Addendum No. 2

RE: Contract ID C203409

Jackson County (B-4554)

Bridge #145 Over SR-1705, Southern Railroad and Scott Creek

PHASE III DETAILS

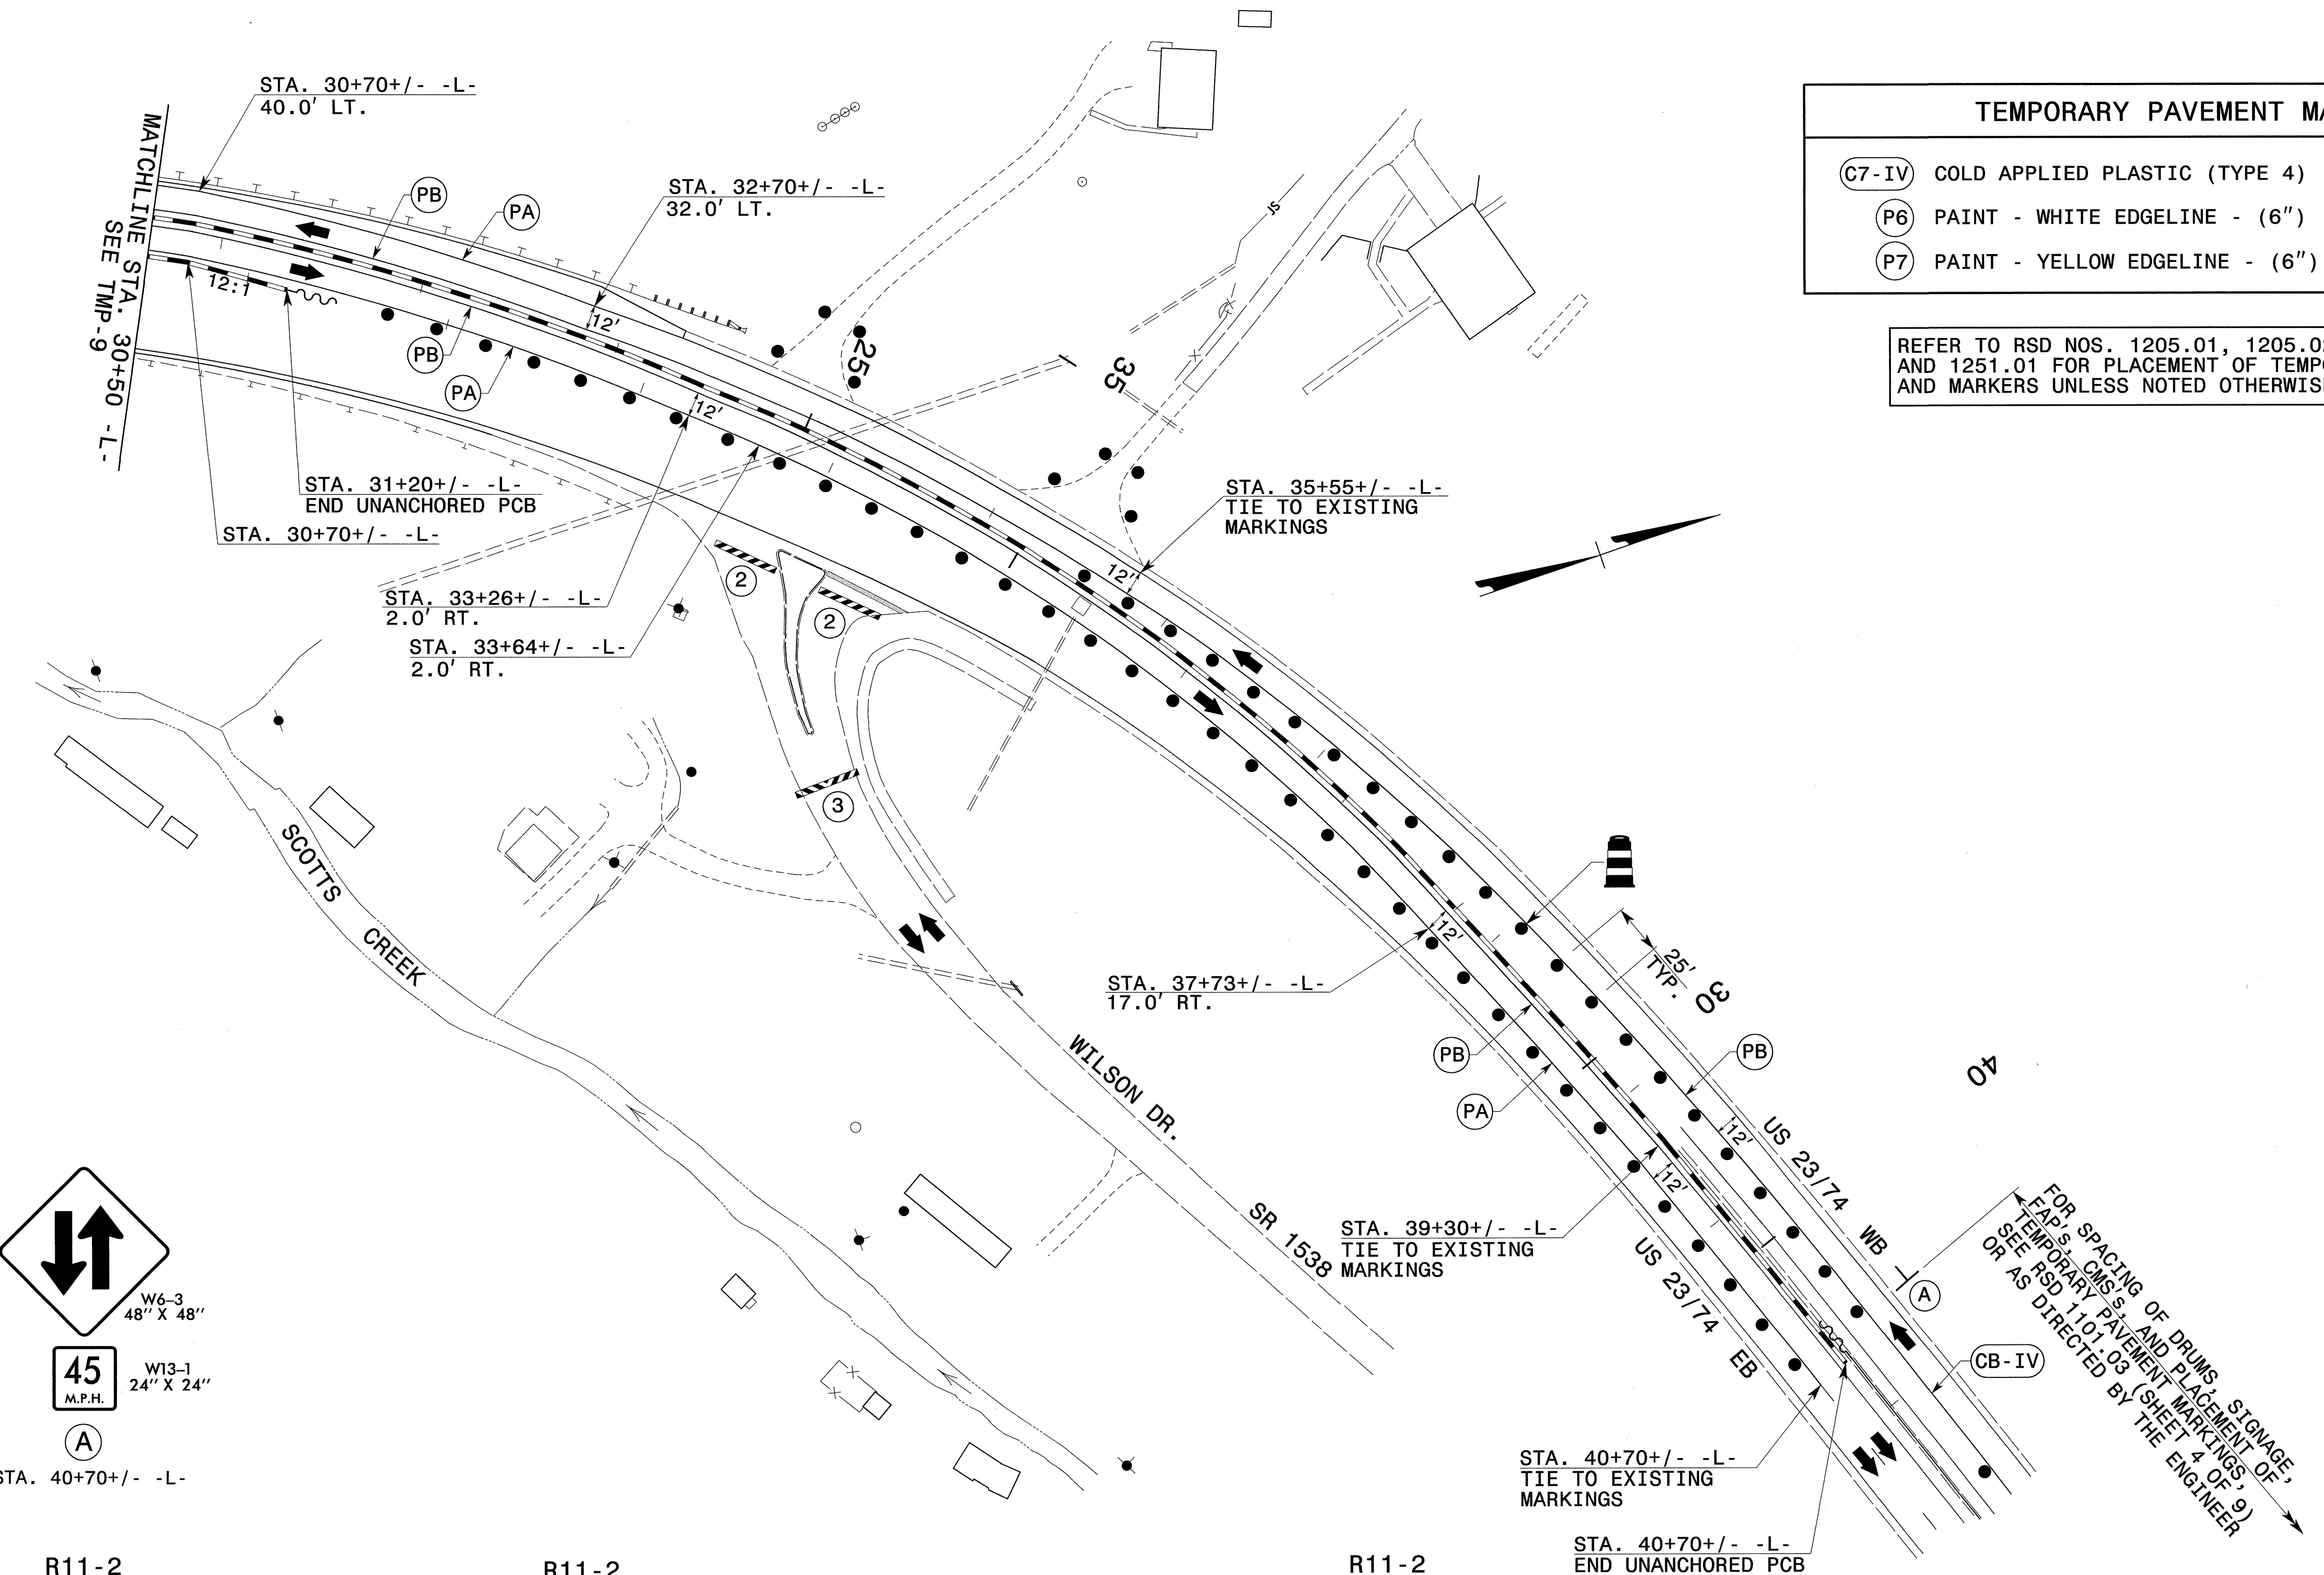
Sheet No.	Revisions
Title Sheet	Revised letting date
TMP-1B	Added Holiday restrictions for -Y1-(Note A) and re-lettered remaining notes
TMP-3	Added Phase II, Step 4A; added Phase III, Step 2A; revised Phase IV, Step 2 to include the remaining -Y1- work be done with flaggers and moved the installation of permanent guardrail on -Y1- to this step
TMP-6	Show permanent guardrail on right side of -Y1- and added note to install permanent guardrail
TMP-9	Removed note about installing permanent guardrail on -Y1-
